**PROPOSED PRINTING, WAREHOUSE AND DISTRIBUTION
FACILITIES**

MAJOR PROJECT APPLICATION NO 08_0016

**SUBMISSIONS REPORT PURSUANT TO SECTION 75(H) OF
ENVIRONMENTAL, PLANNING & ASSESSMENT ACT, 1979**

**133-145 LENORE DRIVE ERSKINE PARK
LOT 62 DP 1090695**

Figure 3: Sectional studies of proposed landscape screen

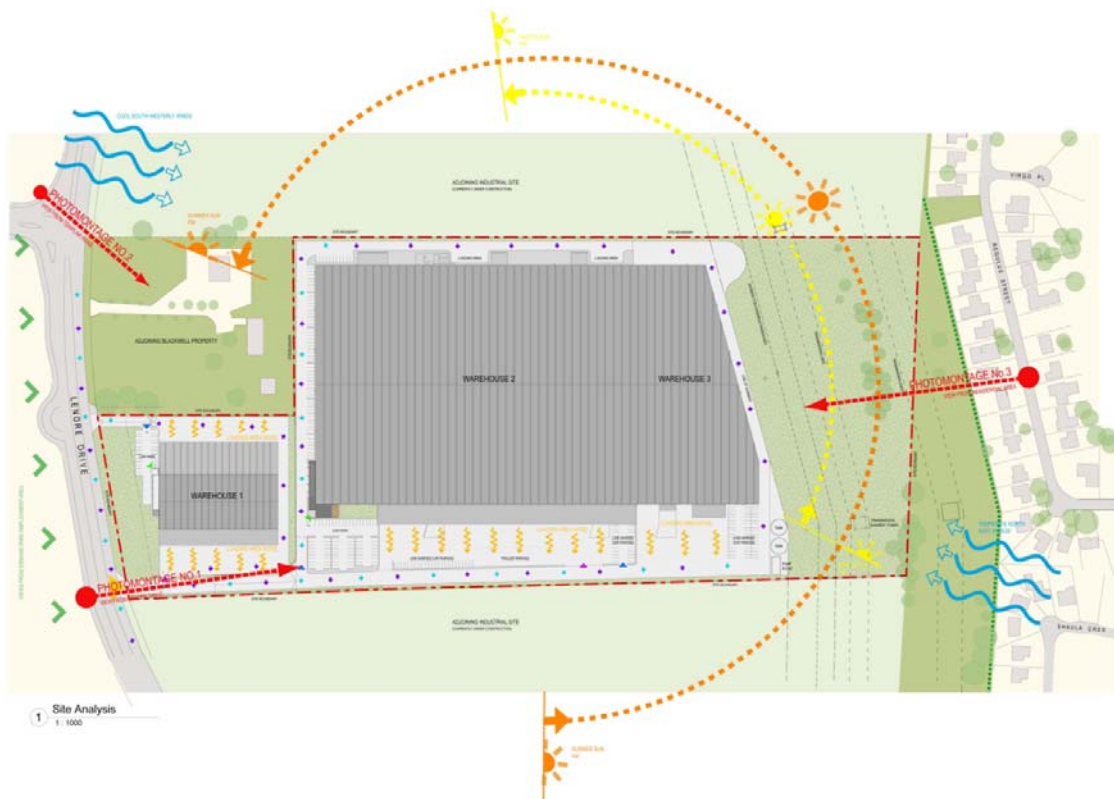
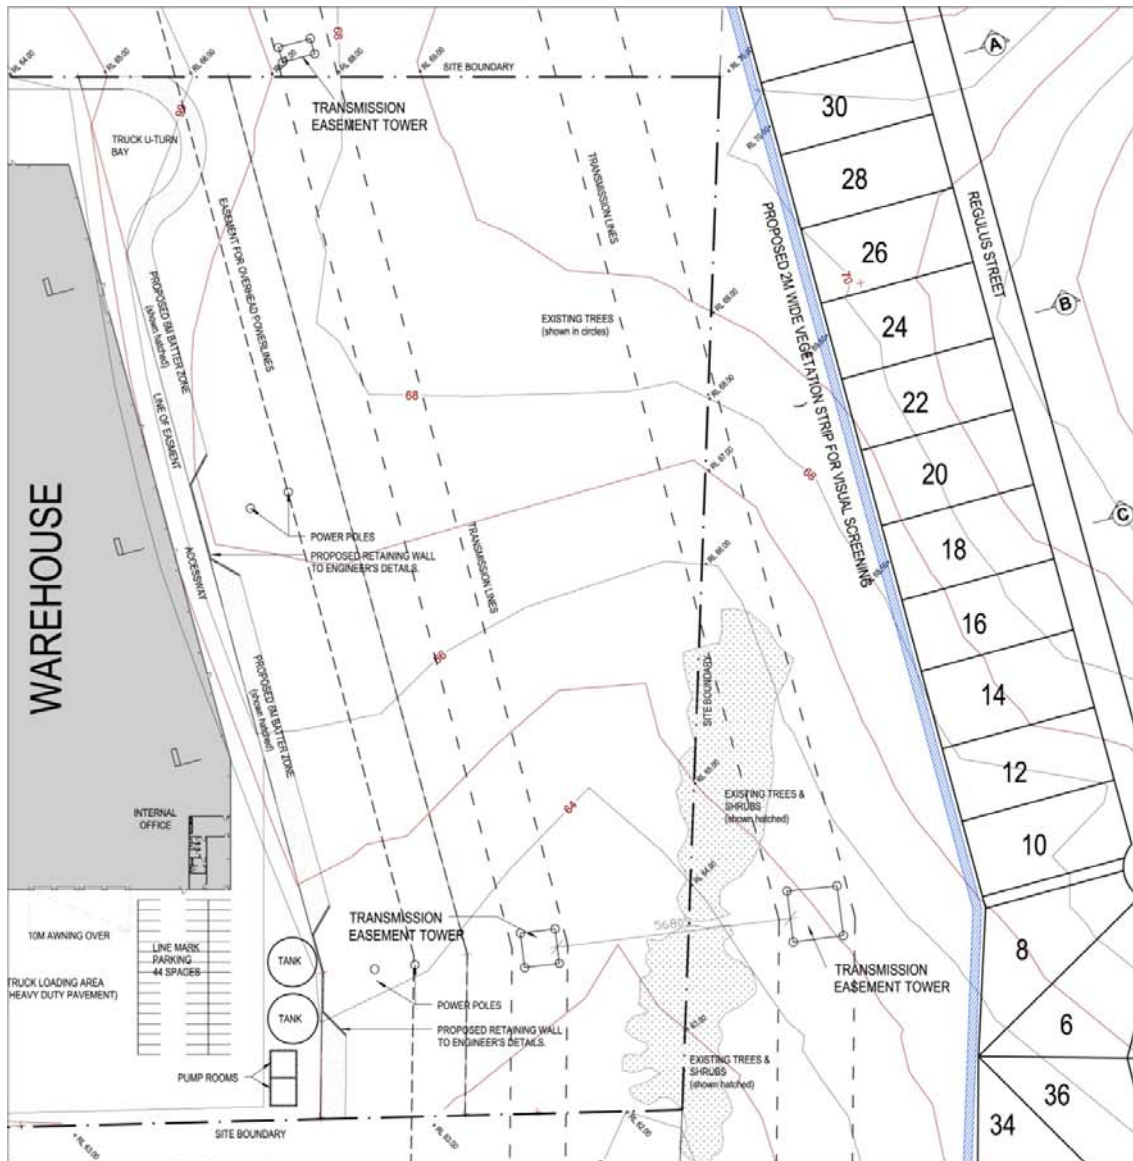
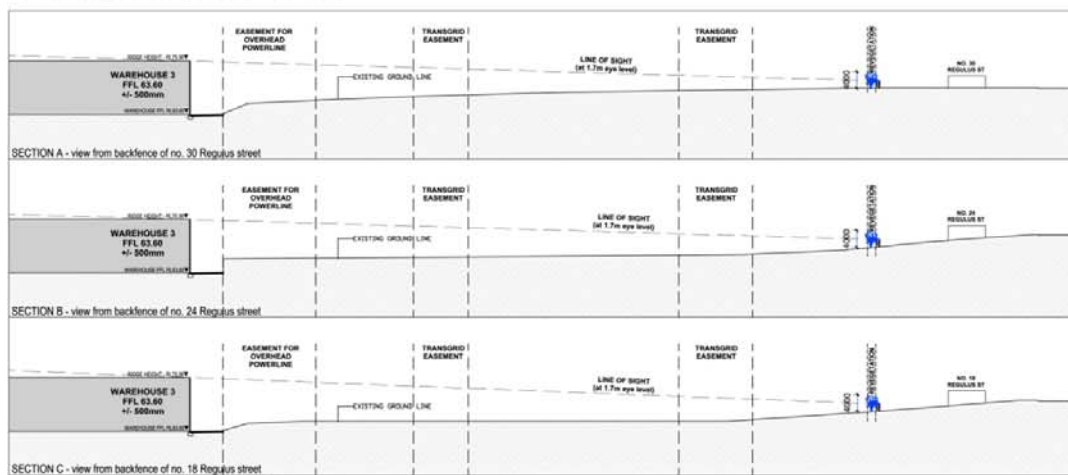
<p>height of these trees selected should be only 4 meters This will NOT shield the view of this development for the residents in Regulus Street Erskine Park. At least 8 metres if not 10 meters high would be required. It would be folly to only consider the residents on the lower side of Regulus Street. (ie the south-side only).</p>	<p>plant species that would grow to a height of 4 to 5 metres to which Transgrid agreed. We now propose to request to increase the height of the trees to 10 metres as suggested by the local resident. However, we plan to retain the screen line along the northern boundary as indicated in our submission thereby catering for residents on both sides of Regulus Street. See Figure 3 of the Visual Impact Assessment Appendix 4.</p>
<p>3. Obviously, such taller vegetation cannot be grown directly under the Transgrid powerlines.</p>	<p>These trees will be well away from the Transgrid power lines and in the outer 2 metres of the easement.</p>

See photographs in Appendix 3.
6. Simple geometry will indicate why such taller trees are required for the elevated residents on the north-side of Regulus Street (see above).	Agreed. They will now be catered for.

2.2 STEPHEN McLOUGHLIN LANDSCAPING COMMENTS	
1. It is highly appropriate that such a landscaped barrier be constructed.	We will be installing a suitable vegetation screen along the northern boundary of the property. Details of the vegetation screen are included in the "Visual Impact Assessment" contained in Volume 2 Appendix 8 of the Environmental Assessment.
